10 Island Street

Christina Stacey <cstacey@portlandmaine.gov>
To: Michael A Ferrante <atlasinsure@aol.com>, hoose@gwi.net
Cc: stegeorge@gwi.net

Chris Stacey - Zoning Specialist
Permitting & Inspections Department
City of Portland
389 Congress St.
Portland, ME 04101
(207) 874-8695
cstacey@portlandmaine.gov

Drawing file: 1. Original Plans / RNT-A-0.0 SITE PLAN.pdf

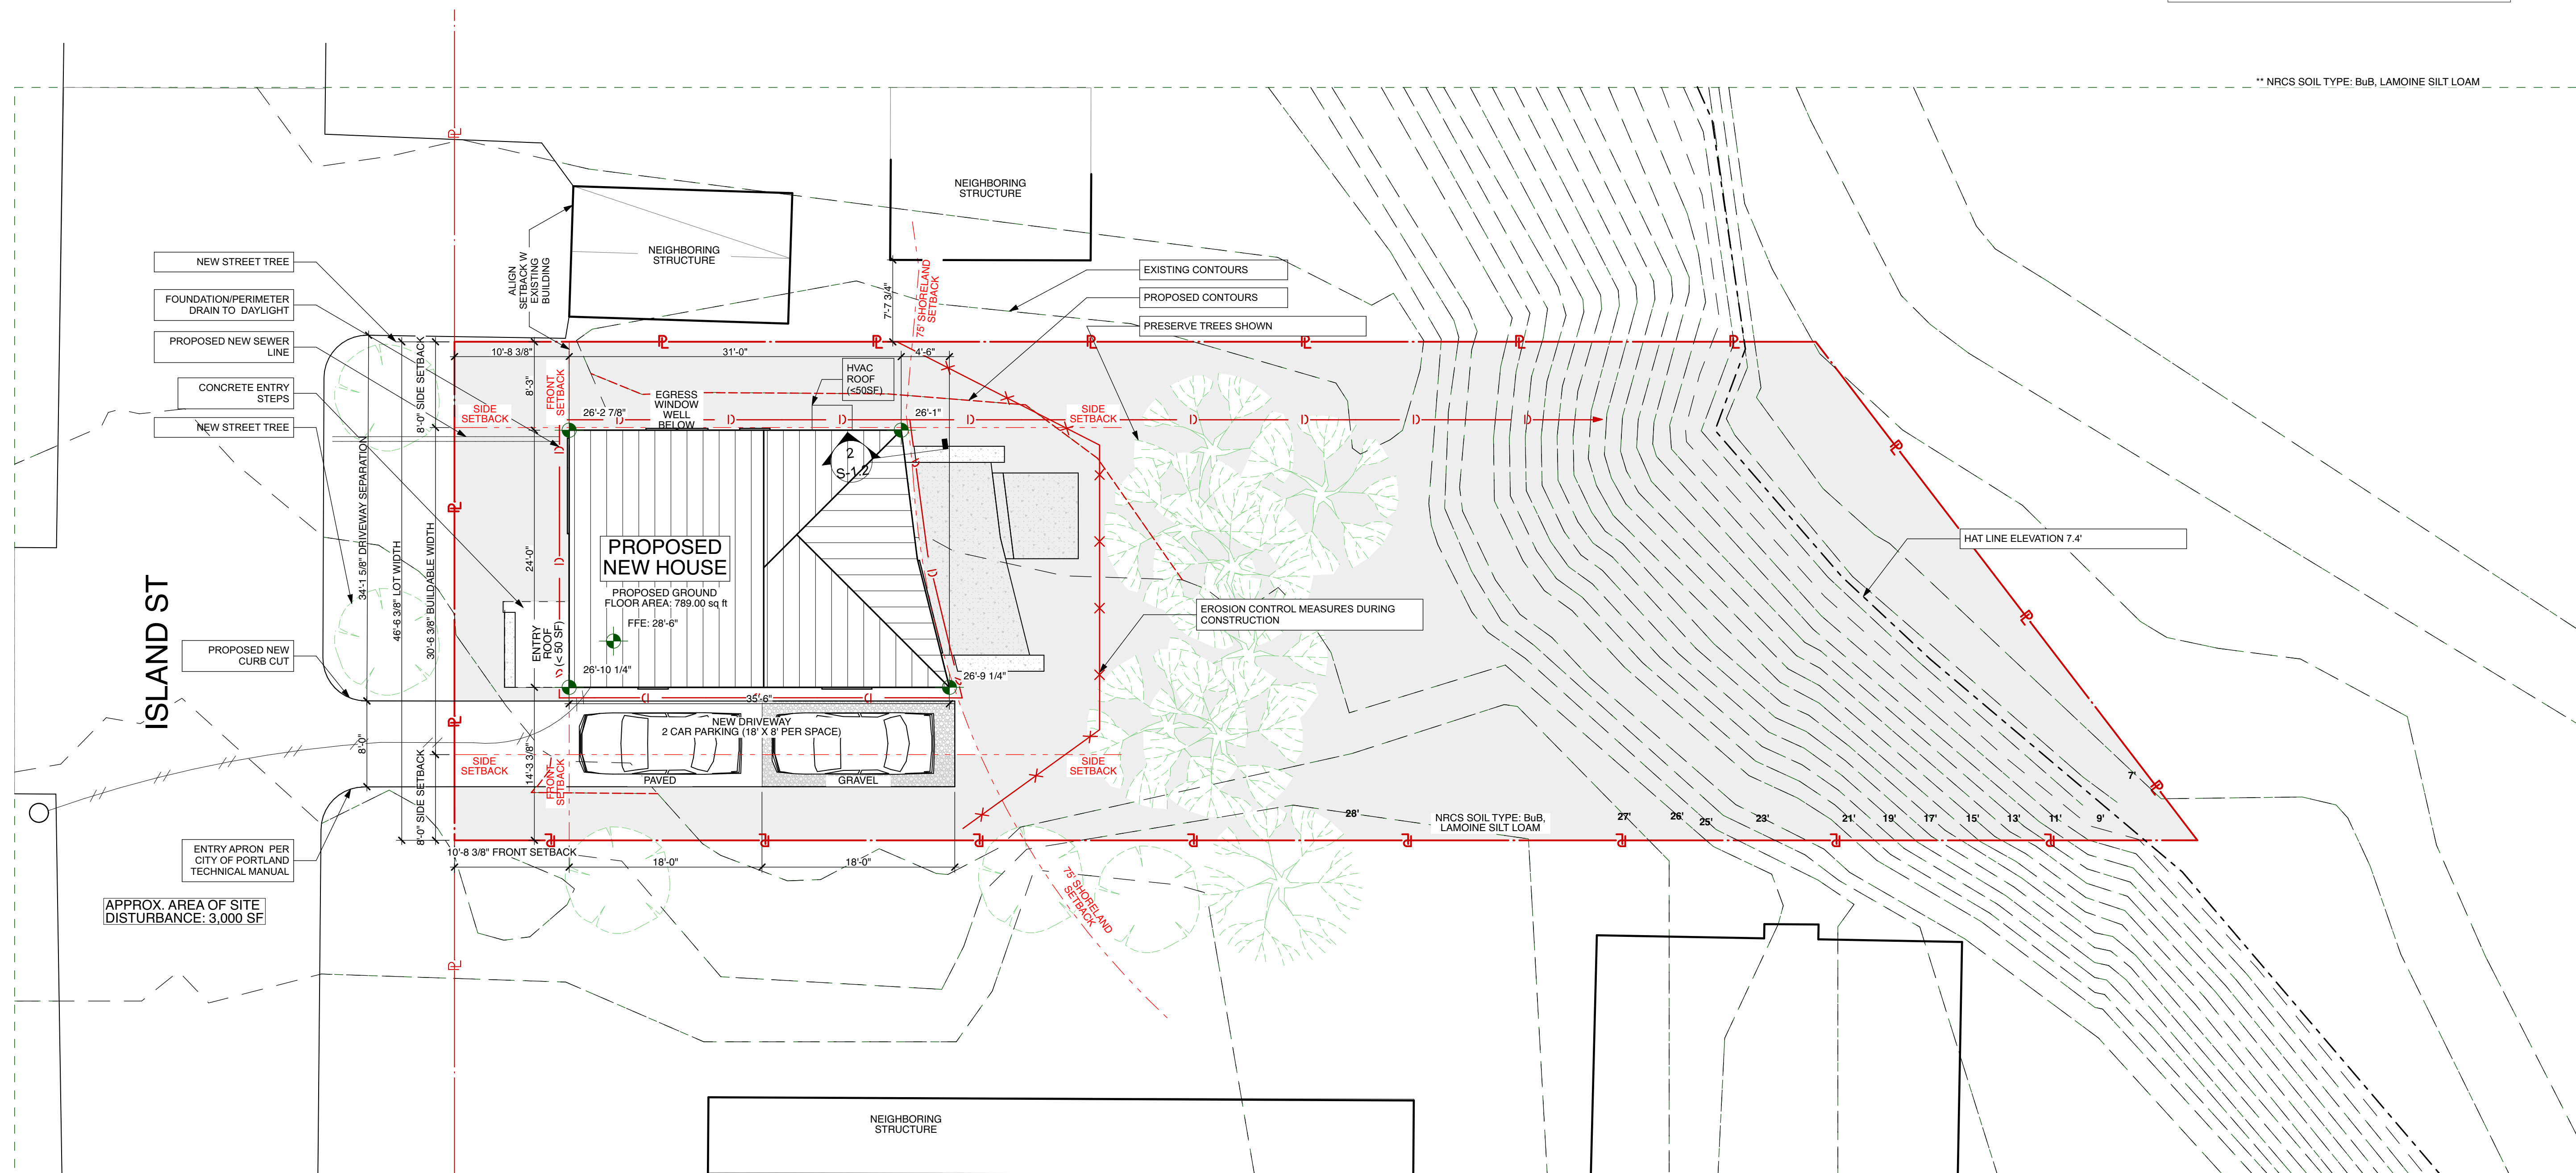
Michael is correct that the required side setbacks for this zone are 8' for a 1- or 1.5-story house or 14' for a 2-story house. Therefore I do not believe the current plans meet the zoning requirement for a 2-story side setback and I have let the architect know.

Section 14-90(d)(1) generally requires a front setback in this zone of 25 feet. However, that section of the ordinance goes on to say that "A front yard need not exceed the average depth of front yards on either side of the lot." The applicant provided information showing that there is one front yard on the left side of the lot, with a depth of 10.7' to the closest building (garage). The property on the right side of the lot has its front yard upon Watson Street and therefore does not need to be averaged into the calculation as interpreted by this office. Therefore I believe that the plans do meet the minimum setback requirement of 10.7' based on the "average" of the one abutter.

**BOUNDARY & TOPOGRAPHIC SURVEY**  
ON  
ISLAND STREET, PORTLAND, MAINE  
MADE FOR RECORD OWNER  
**DONALD PETERSON**  
74 WATSON STREET, PORTLAND, MAINE

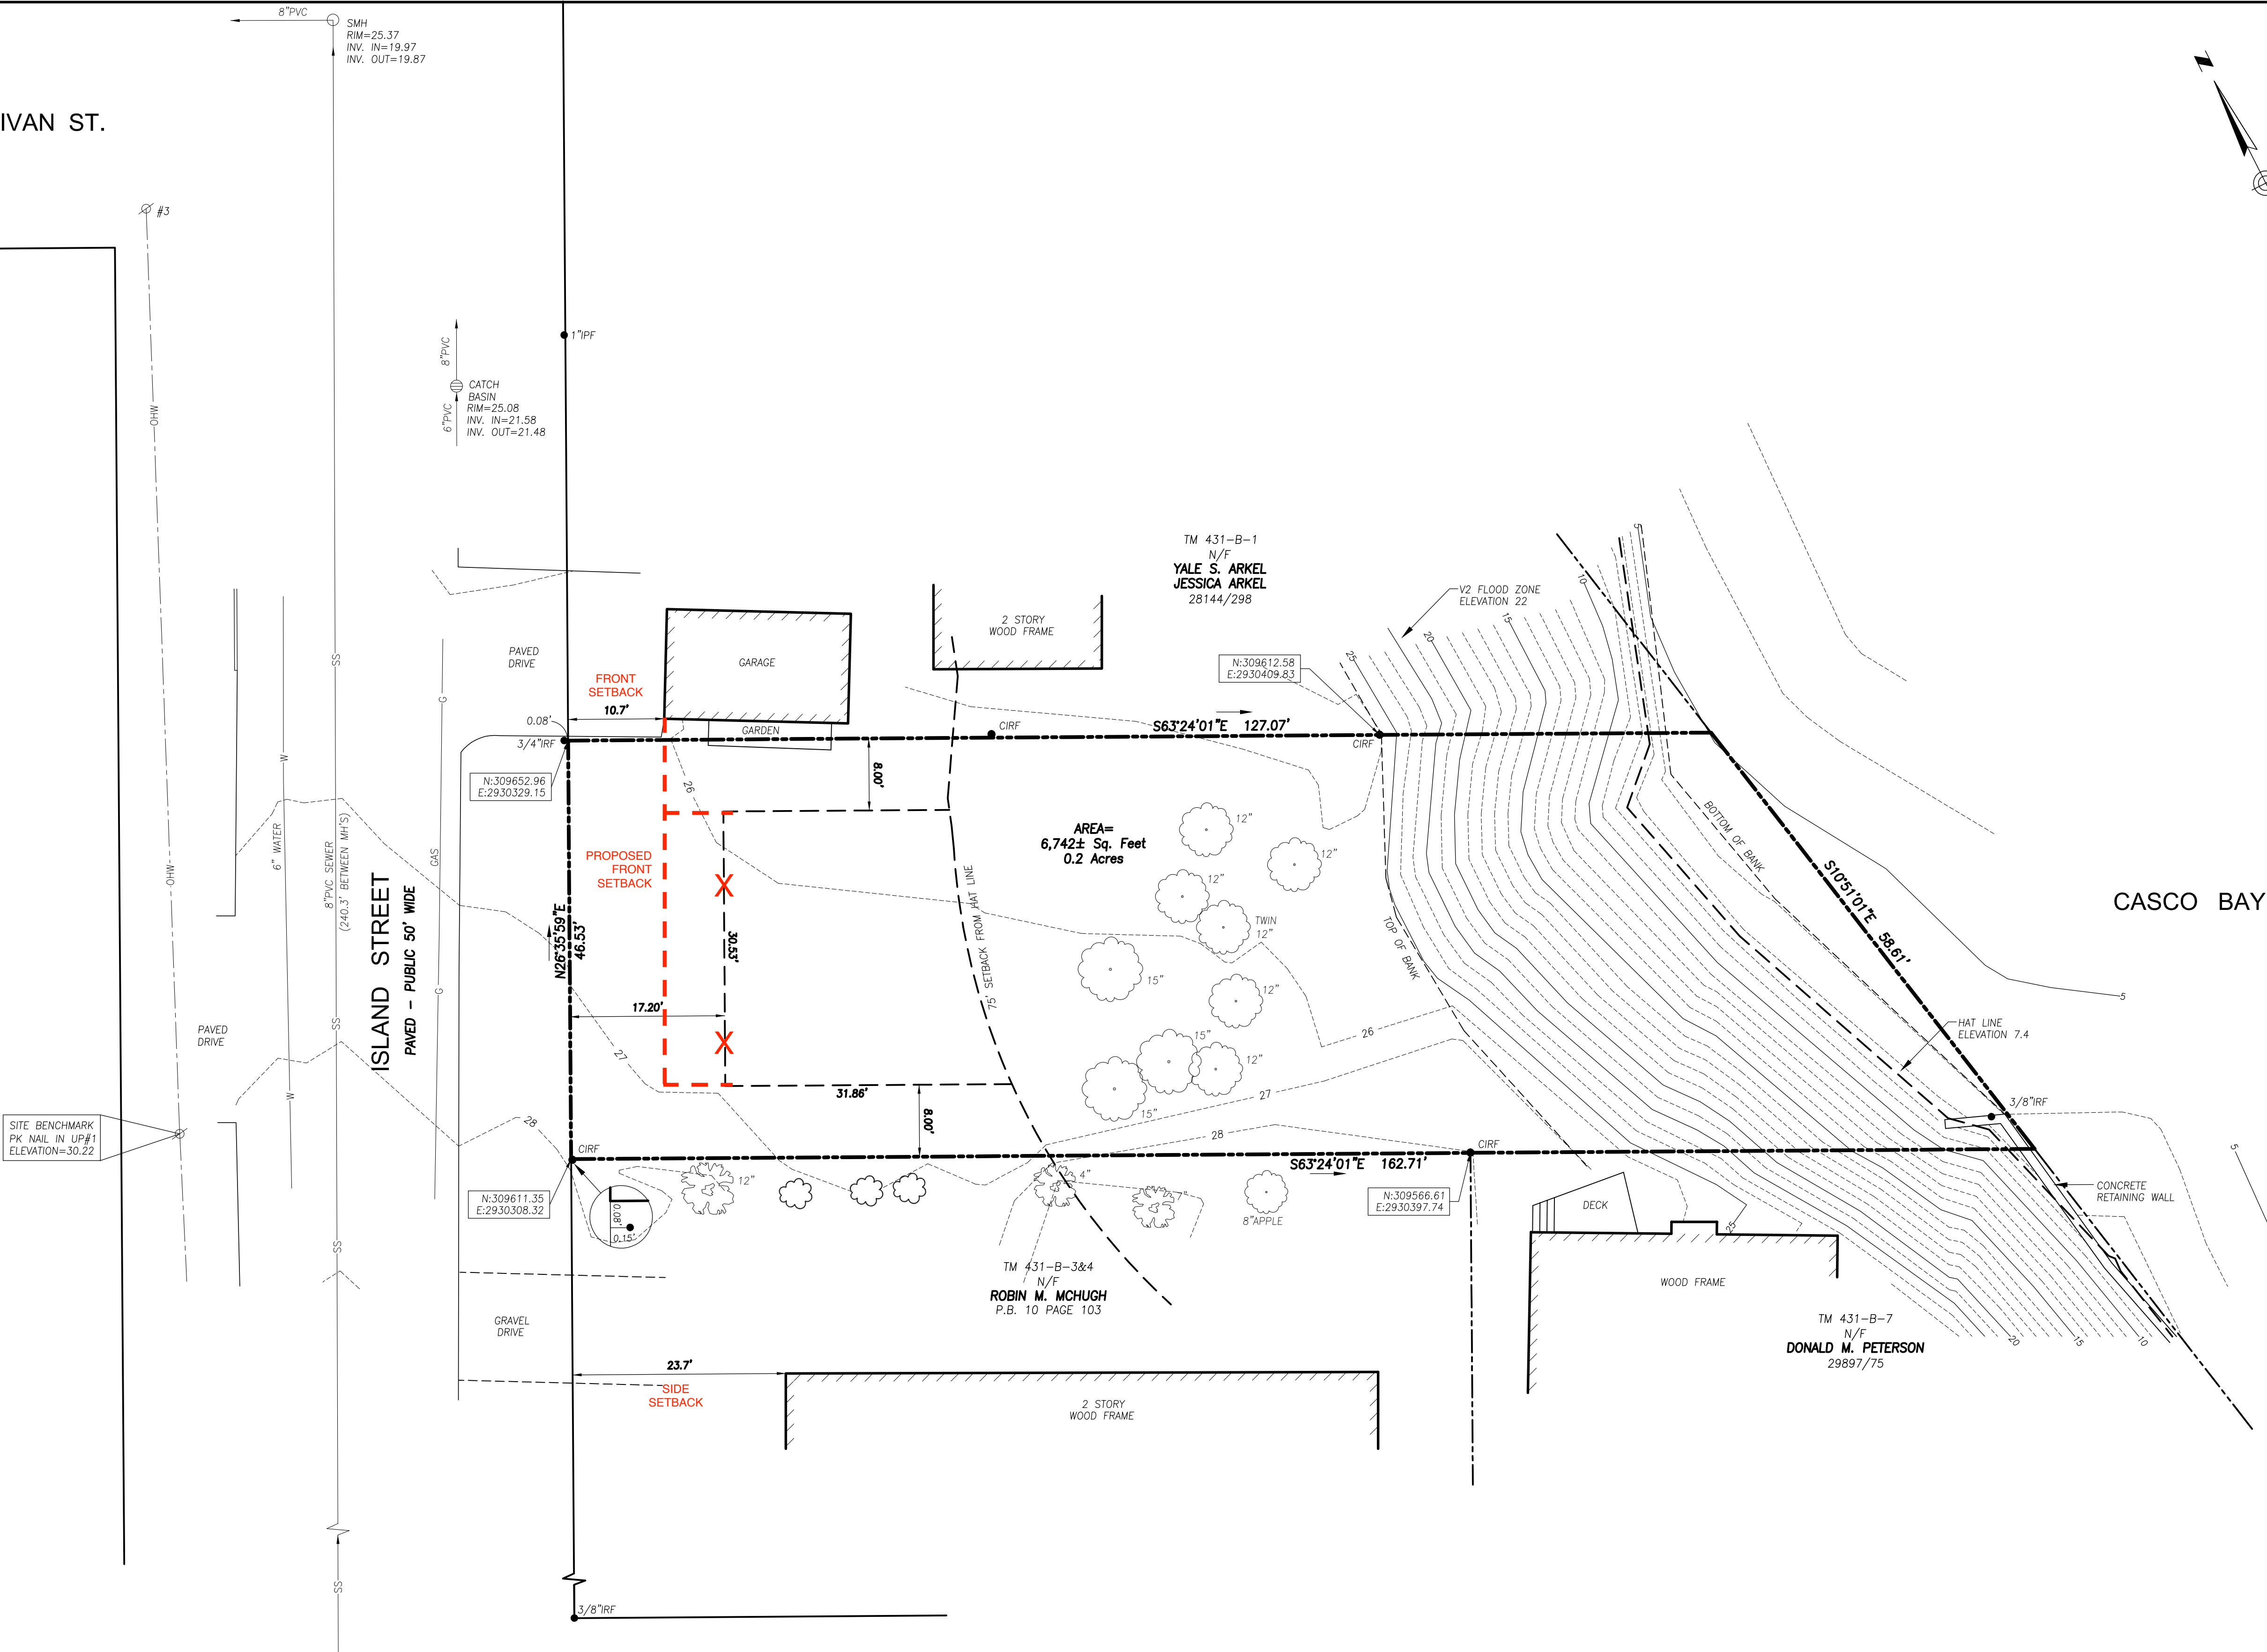
One question is, since the survey of the 10 Island Street property was done in 2015 when the HAT was 11.5, had or will it be remeasured to the 2017 HAT, which is higher??

In regards to your question about the HAT line and 75' setback, I am not sure what the 11.5' elevation you refer to is based on? The city goes by the [HAT table provided by DEP](#). The second column, showing the HAT levels for various points in the NAVD88 datum, is the one that most surveyors use to locate the HAT on a survey (not the MLLW method, which you might be referring to). I believe the closest point to the Island Street property is the Presumpscot River bridge, which shows a HAT elevation of 6.9'. The survey for 10 Island Street shows a HAT elevation of 7.4', which is different because the survey was created using the NGVD 1929 datum, so a conversion needed to be made. It is my understanding that the conversion from NAVD88 to NGVD 1929 for this area is about +0.7', which jibes with what is presented on the survey. Therefore I believe the HAT elevation shown on the plan to be correct and perhaps even conservative. If you have further information that you believe shows this level to be incorrect, please let me know.
